RE: McDonald's #32-0051  
1726 W. Cumberland St.  
Dunn, NC 28334

The letter acknowledges review of the remodel plan for the above reference establishment. The plans received on 07/25/2023, application and drawings, specifications, including e-mail correspondence and are approved with the following comments:

Sheet Number  
**P-101**

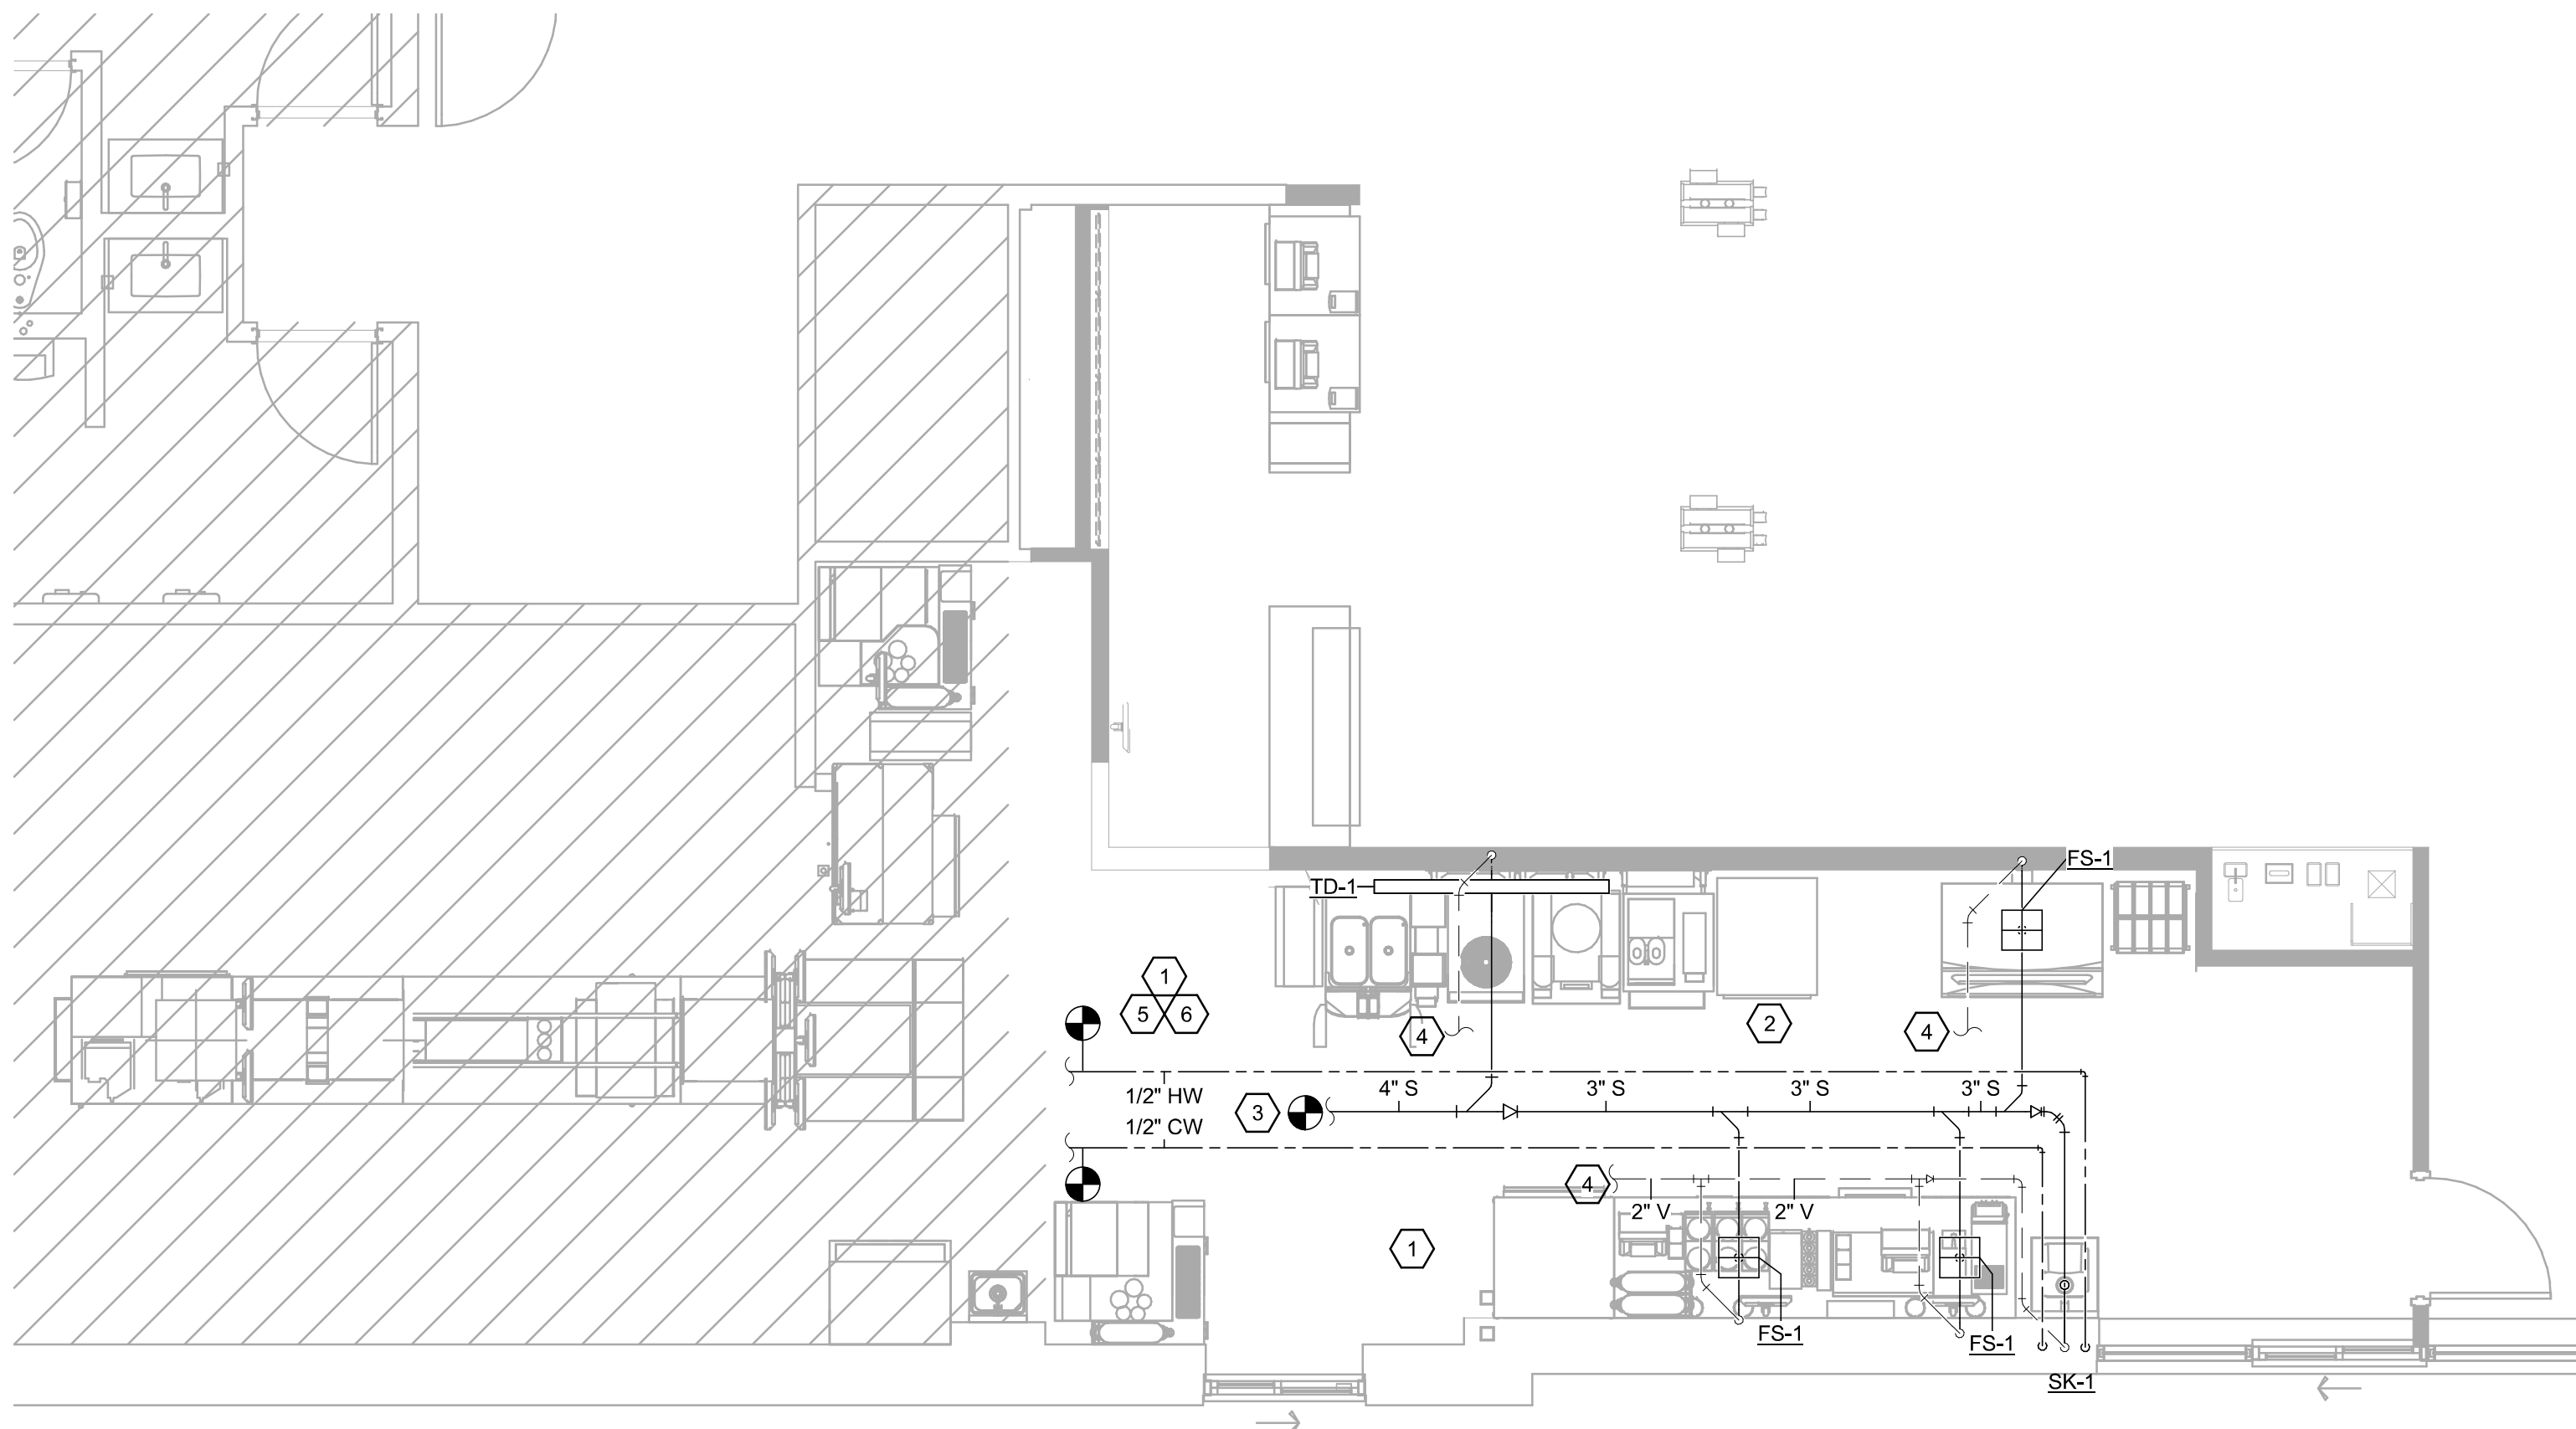
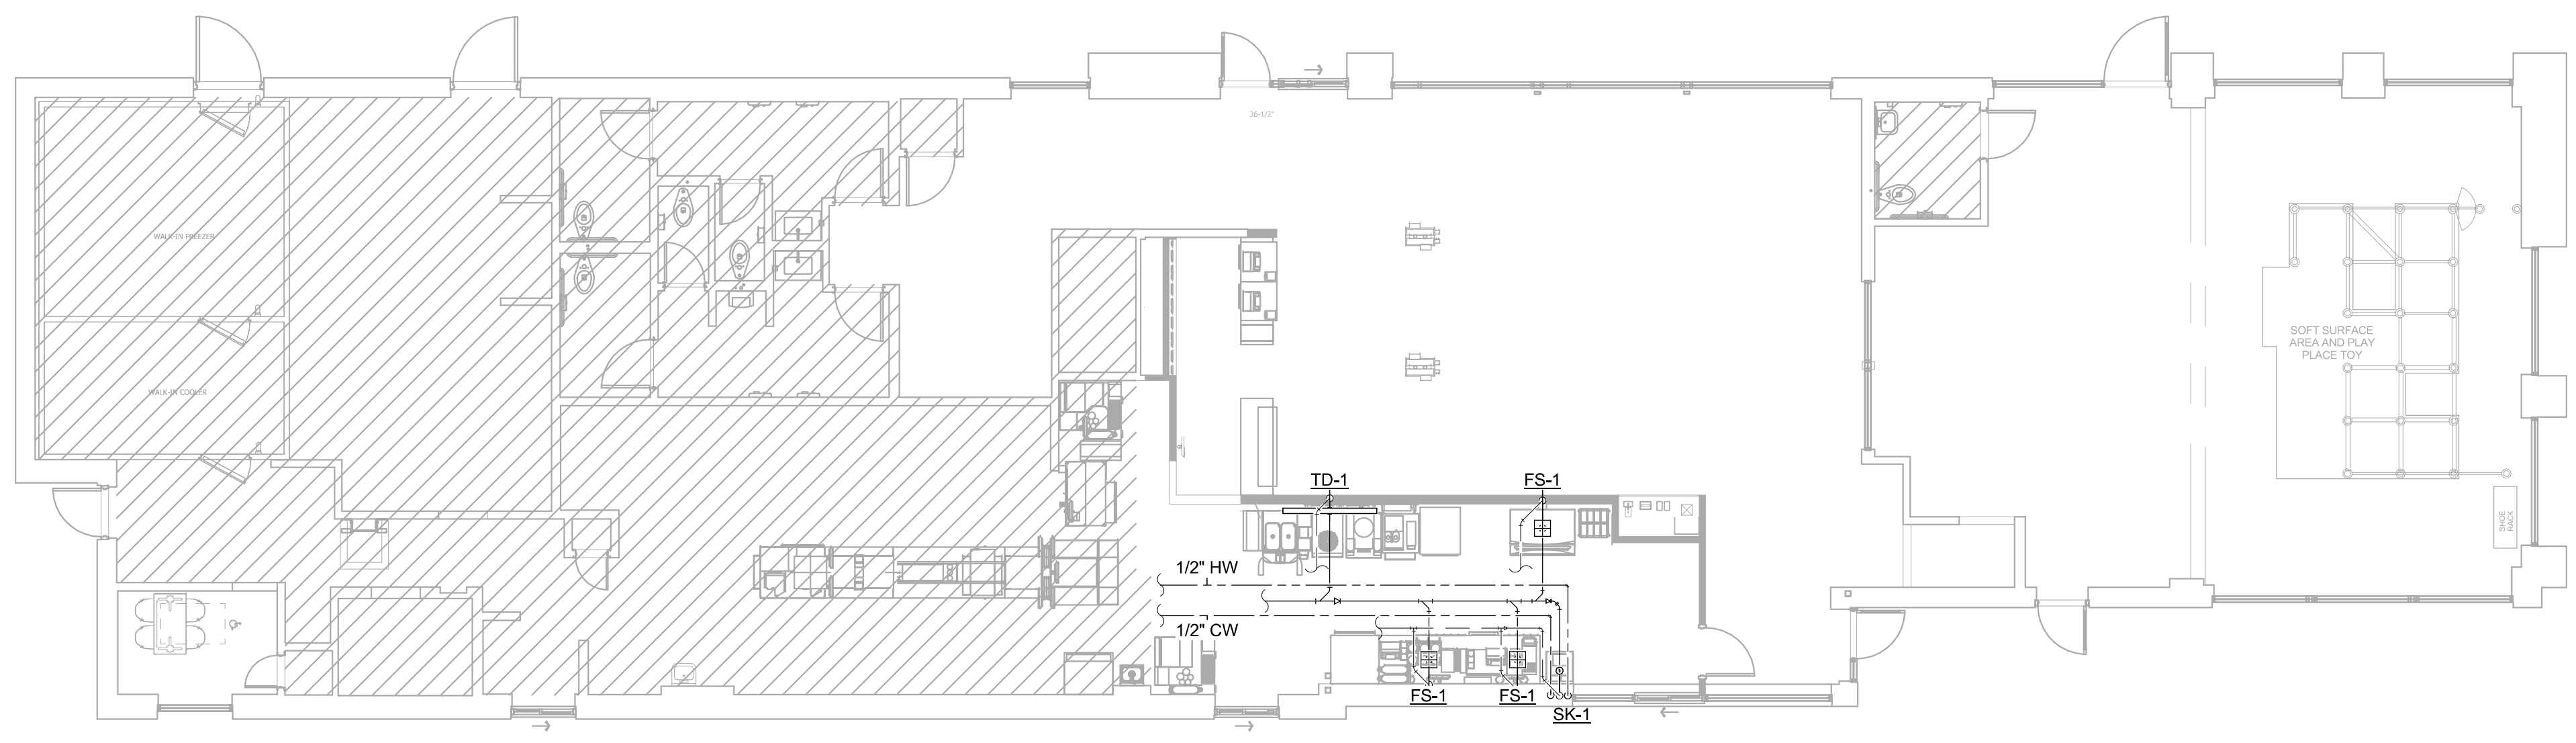
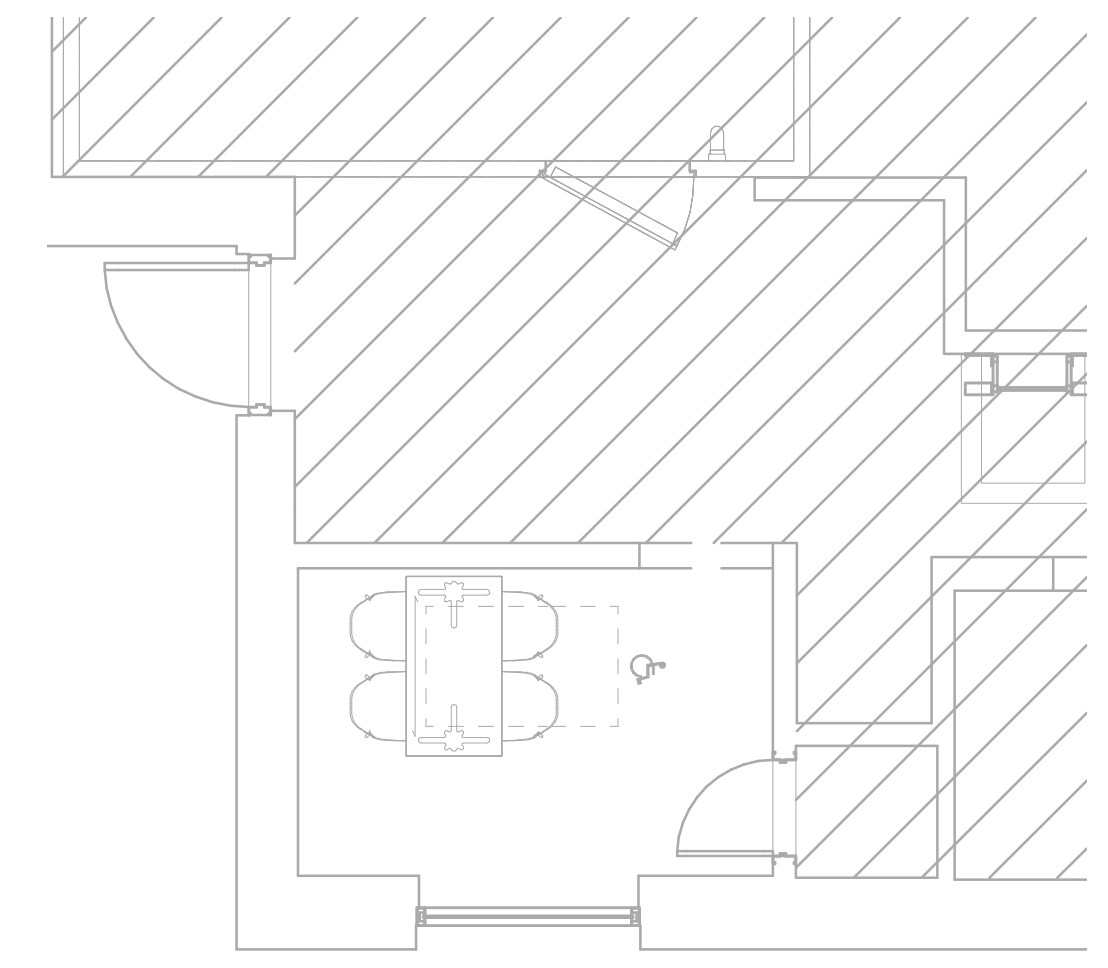
3. In addition, a new hand sink will be installed at this pick-up counter area, to supply convenient and accessible hand washing to all food preparation, and food dispensing areas and to meet NC Food Code requirements.
